CRANBROOK SCHOOL HORDERN PRECINCT PROJECT

STATE SIGNIFICANT DEVELOPMENT APPLICATION ACCESSIBILITY REPORT

Morris-Goding Accessibility Consulting

Figure 22 – GA Plan – Level 02

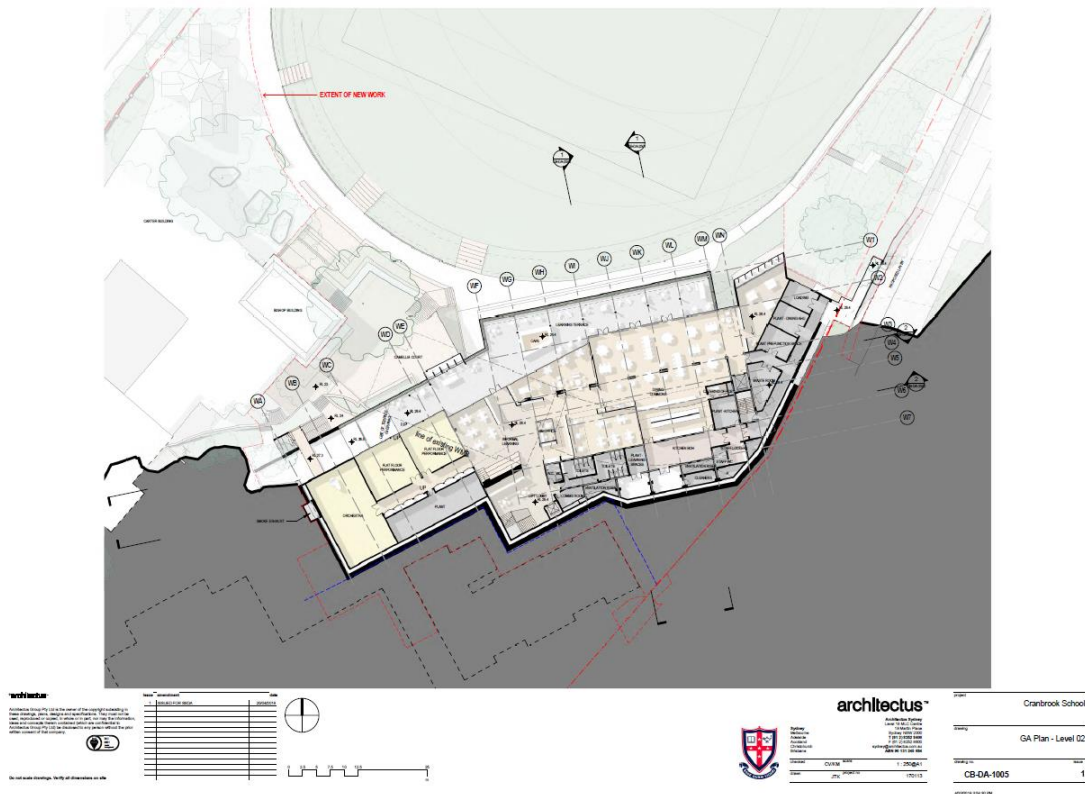
From the information provided, the architect had proposed a ramp that will provide an accessible linkage from the learning terrace on level 02 to the existing School area at RL 28. There is also proposed level access from level 04 external area to the existing School (near the admin building) at RL 34.9. These accessible linkages will promote a continuous accessible path of travel to the 2 passenger lifts that access all levels of the proposed building. However latest revision of drawings has omitted this.

- (i) From previous revisions of drawings provided, the architect had discussed and proposed a ramp that will provide an accessible linkage from the learning terrace on level 02 to the existing School area at RL 28. Refer to drawing WMH-SK196 – 10/20/17. This or another solution are a requirement to achieve an accessible path of travel between the 2 buildings. This can be fine-tuned in the design development stage.

Figure 38 – GA Plan B1 (Concourse)

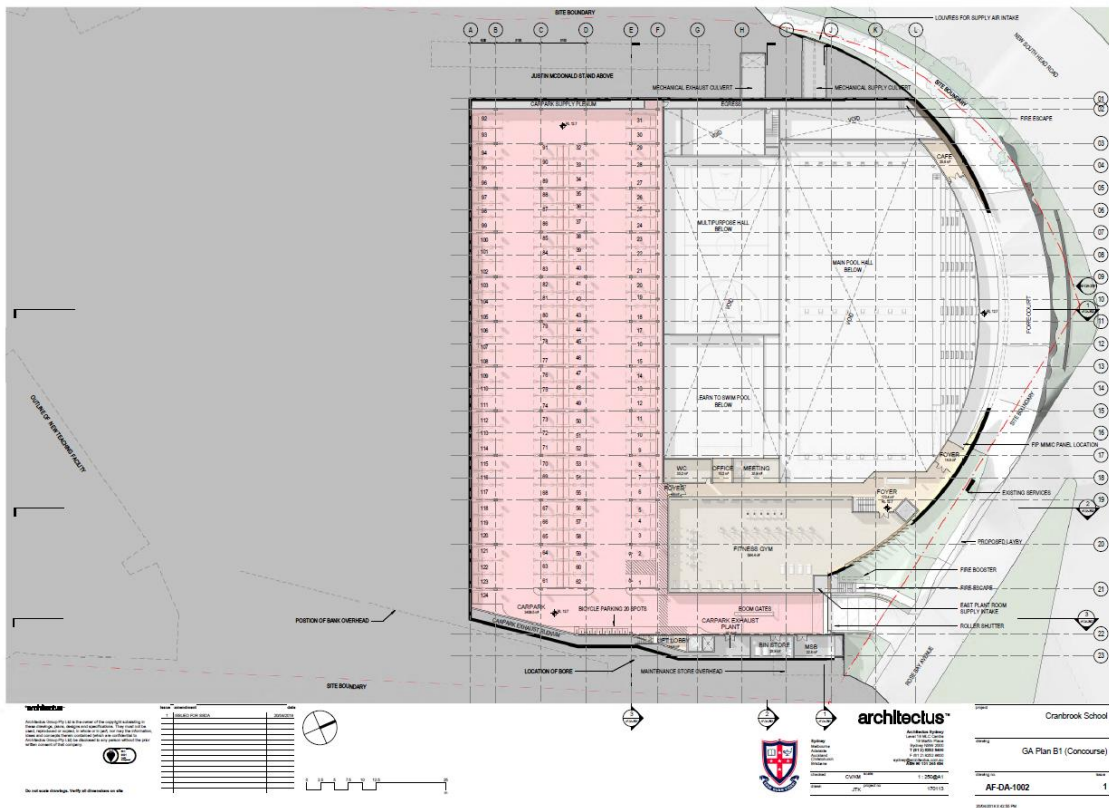
There are two separate banks of turnstile gates between the entry lobby and the main pool hall lobby. The provision of one wheelchair-accessible gate will be required.

The egress paths of travel from level B1 of the Aquatic and Fitness Centre building are either via the principal pedestrian entrance on New South Head Road, or via the single-leaf hinged egress door from the secure corridor, as shown on drawing ARC-DA-1002 near grid reference HL.H2.

There are two separate common-use stairways that each run from level B1 to B2 within the Aquatic and Fitness Centre building, as shown on drawing ARC-DA-1002 at grid references H7.HI and H2.HJ respectively.

- (i) All of the above stairways will be detailed to possess appropriate access features for compliance with AS1428.1(2009) during design development stage.
- (ii) Clarification from BCA consultant/PCA is required to satisfy BCA Part D2.17 for the height of the top of the handrail to be at a consistent height (AS1428.1 clause 12e), in particular throughout stair flights and if provided as inner handrail over landings. Recommend tread offset at the base of each flight of stairs or by increasing stair landings by 300mm min. length to allow for handrail to extend and continue at consistent height.

Figure 39 – GA Plan B2 (Pool)

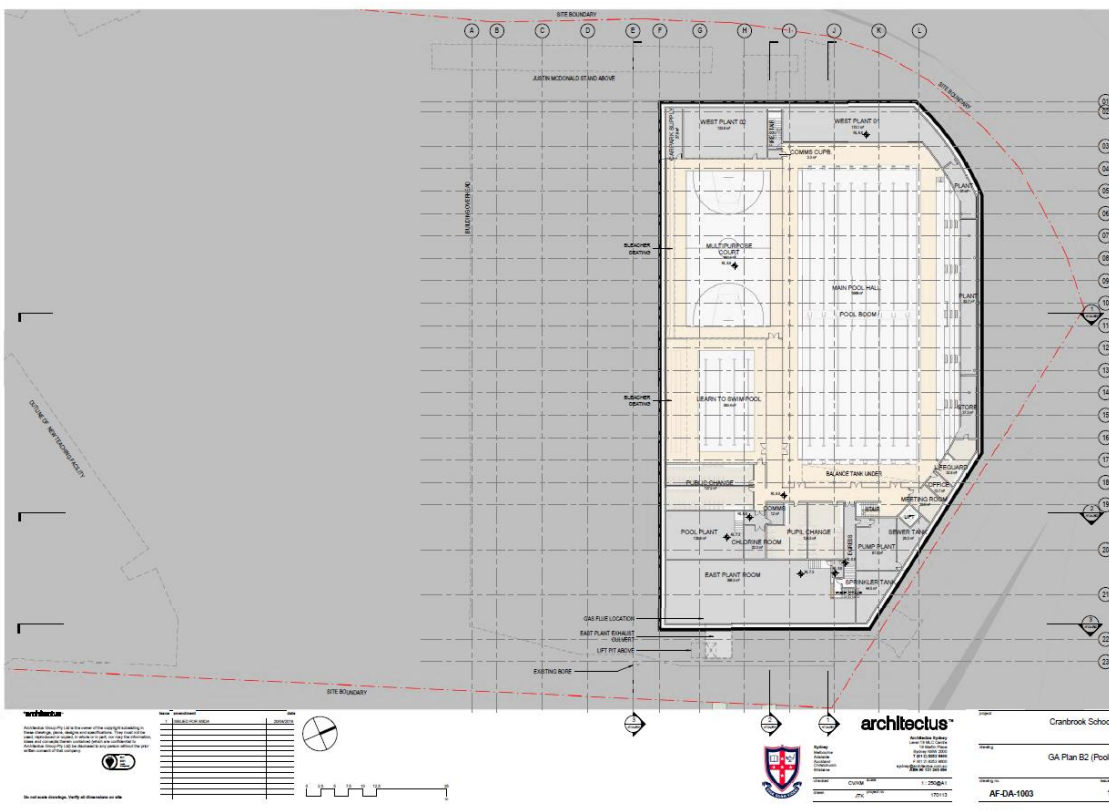
Egress from level B2 of the Aquatic and Fitness Centre building is via either fire stair 1 or 2 that are shown on drawing ARC-DA-1003 respectively at grid references HL.H7 and HB.H7. Both of the above stairways will be capable of meeting the minimum accessible egress requirements of the DDA Access Code 2010 and the BCA.

- (i) Provide at least one handrail within each fire-isolated stairway.
- (ii) Clarification from BCA consultant/PCA is required to satisfy BCA Part D2.17 for the height of the top of the handrail to be at a consistent height (AS1428.1)

clause12e), in particular throughout stair flights and if provided as inner handrail over landings. Recommend tread offset at the base of each flight of stairs or by increasing stair landings by 300mm min. length to allow for handrail to extend and continue at consistent height.
